Subject: Rezoning Petition Review

Rezoning Petition #: 21-021

Location of Property: Approximately 27.65 acres located on the north side of State Street, southwest of Rozzelles Ferry Rd and east of Tuckaseegee Rd.

SHEET NUMBER **RZ-01**CITY OF CHARLOTTE

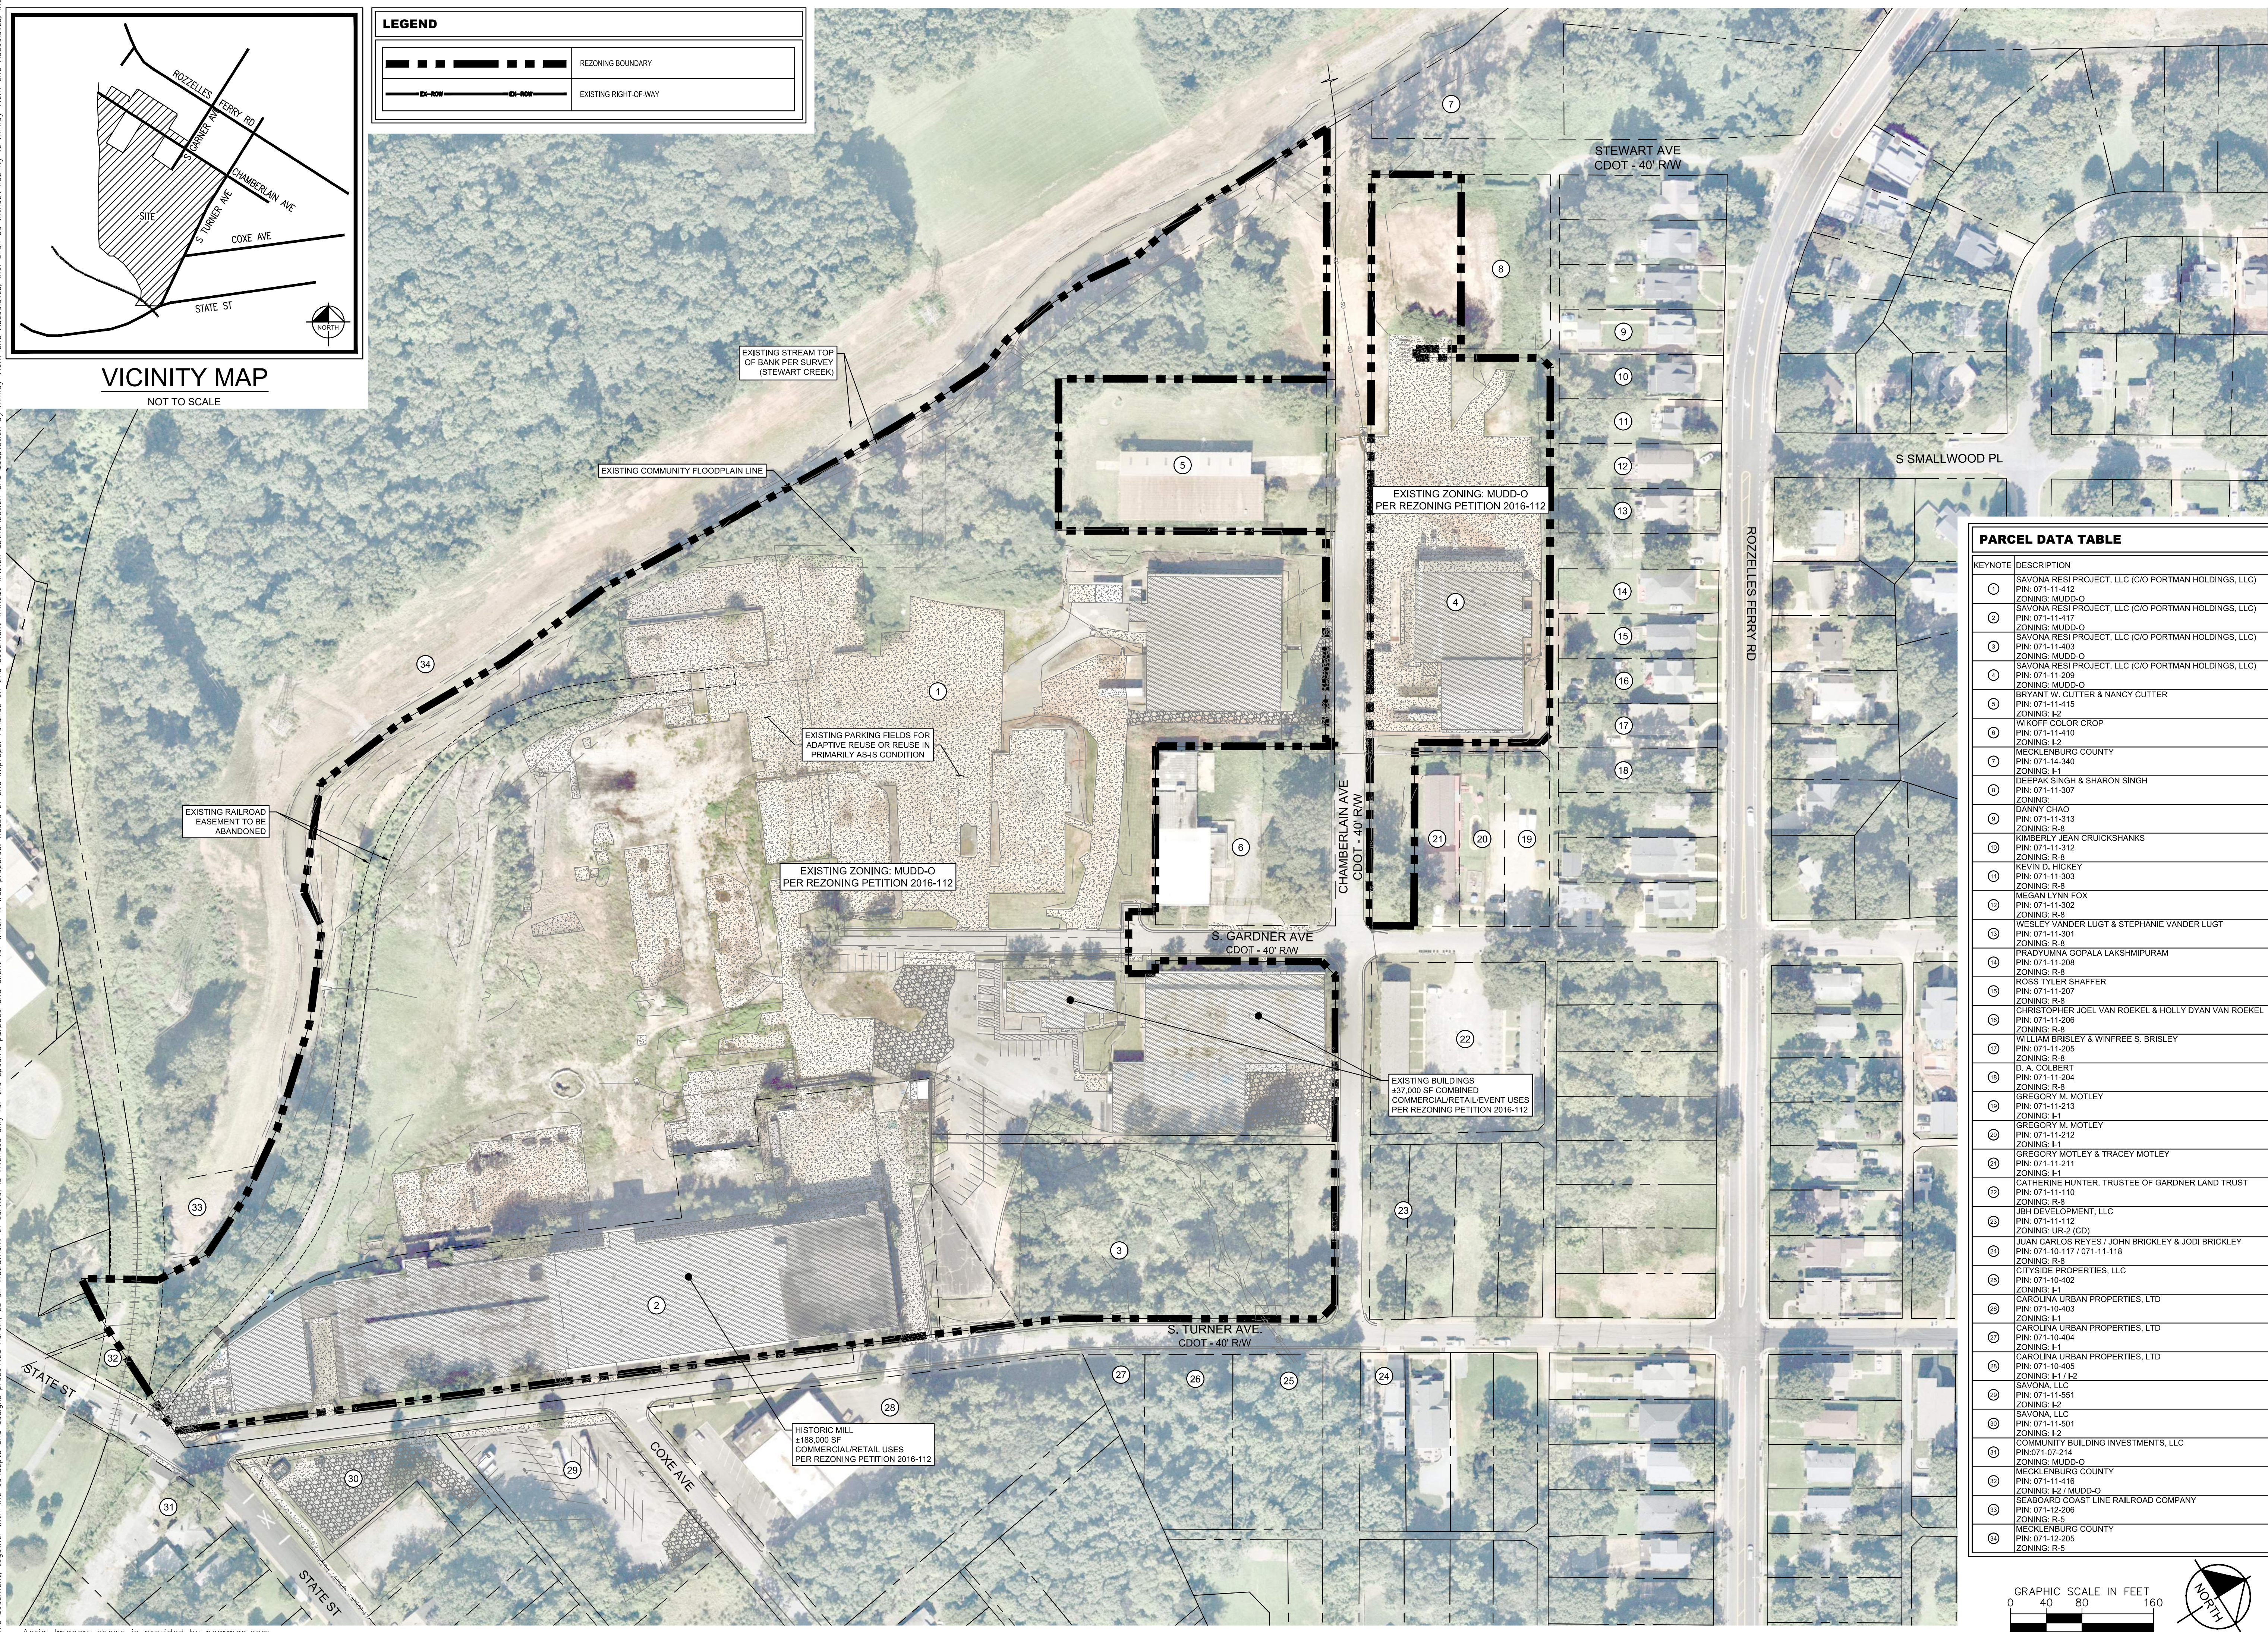
The rezoning plan sheet indicates a proposed location for storm water management. Please include the following notes on the plan sheet under "Environmental Features": *The location, size, and type of storm water management systems depicted on the Rezoning Plan are subject to review and approval as part of the full development plan submittal and are not implicitly approved with this rezoning. Adjustments may be necessary in order to accommodate actual storm water treatment requirements and natural site discharge points.*

Please include the following note under "Environmental Features": *Development within the SWIM/PCSO Buffer shall be coordinated with and subject to approval by Charlotte-Mecklenburg Storm Water Services and mitigated if required by City ordinance.*

Please note Charlotte-Mecklenburg Storm Water Services (CMSWS) has a Storm Drainage Easement (SDE) of varying width over this pipe as recorded in map book 13341 page 19. No buildings or structures are permitted over and across this easement.

This property drains to Irwin Creek, which is an impaired/degraded stream, and may contribute to downstream flooding. This project has the opportunity to mitigate future impacts to this stream, therefore, Storm Water recommends placing the following notes on the plan:
